# Planning Services Sign Permit Review Form

Date of Submittal	Application Number	Applicant	Landowner
3/29/2022	SIGN2203-0008	Parish Sign	Harrell Land Group LLC

Contact Person	Contact Number	Sign Location	PIN Number
Michael Bassett	910-875-6121	Front Elevation	9594-07-3910.000

**FACE VIEW OF SIGNAGE WITH DIMENSIONS**

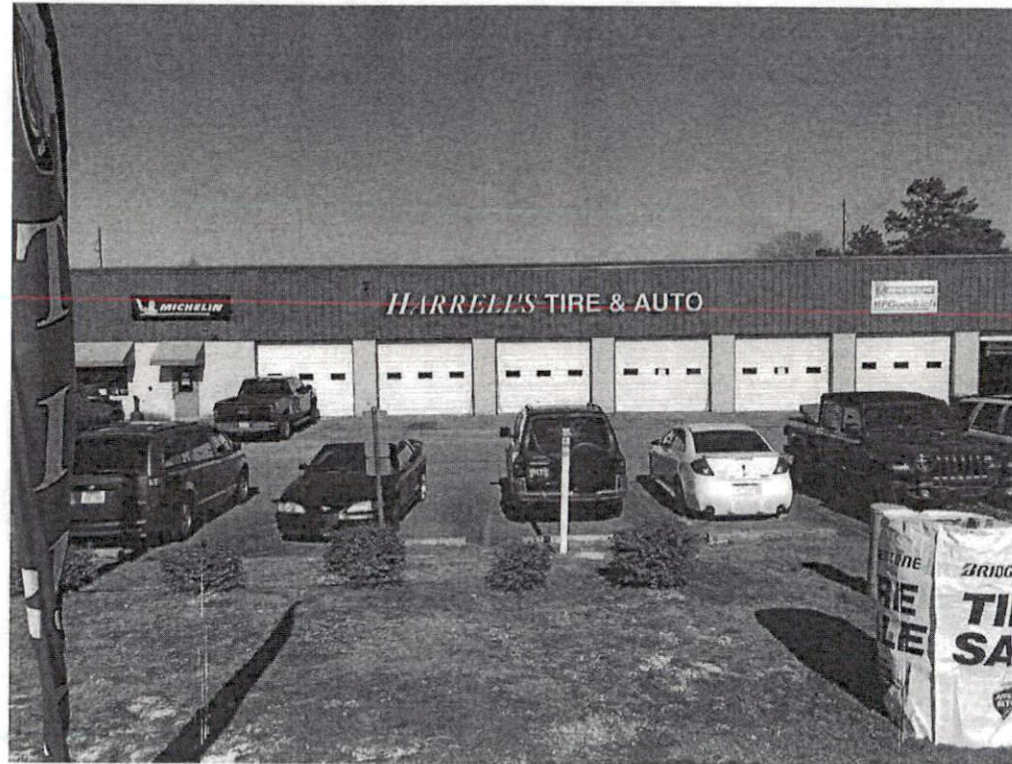
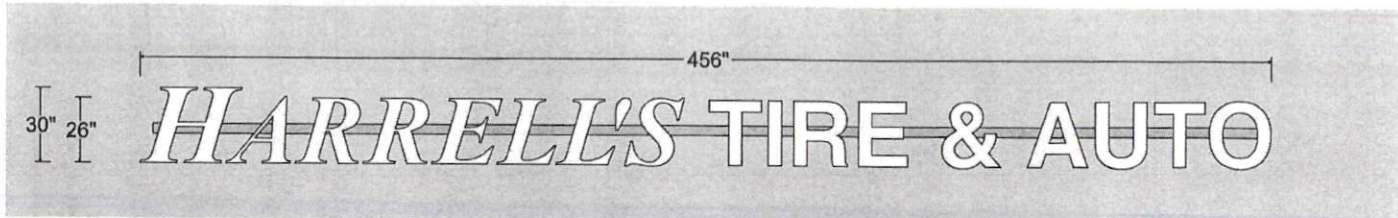
Comments	More Information required. <ol style="list-style-type: none"> <li>1. Submit a site plan with the existing signage. The width and the height of all existing wall signage is required.</li> <li>2. Provide the measurement in feet of the mounting wall.</li> </ol>
----------	--
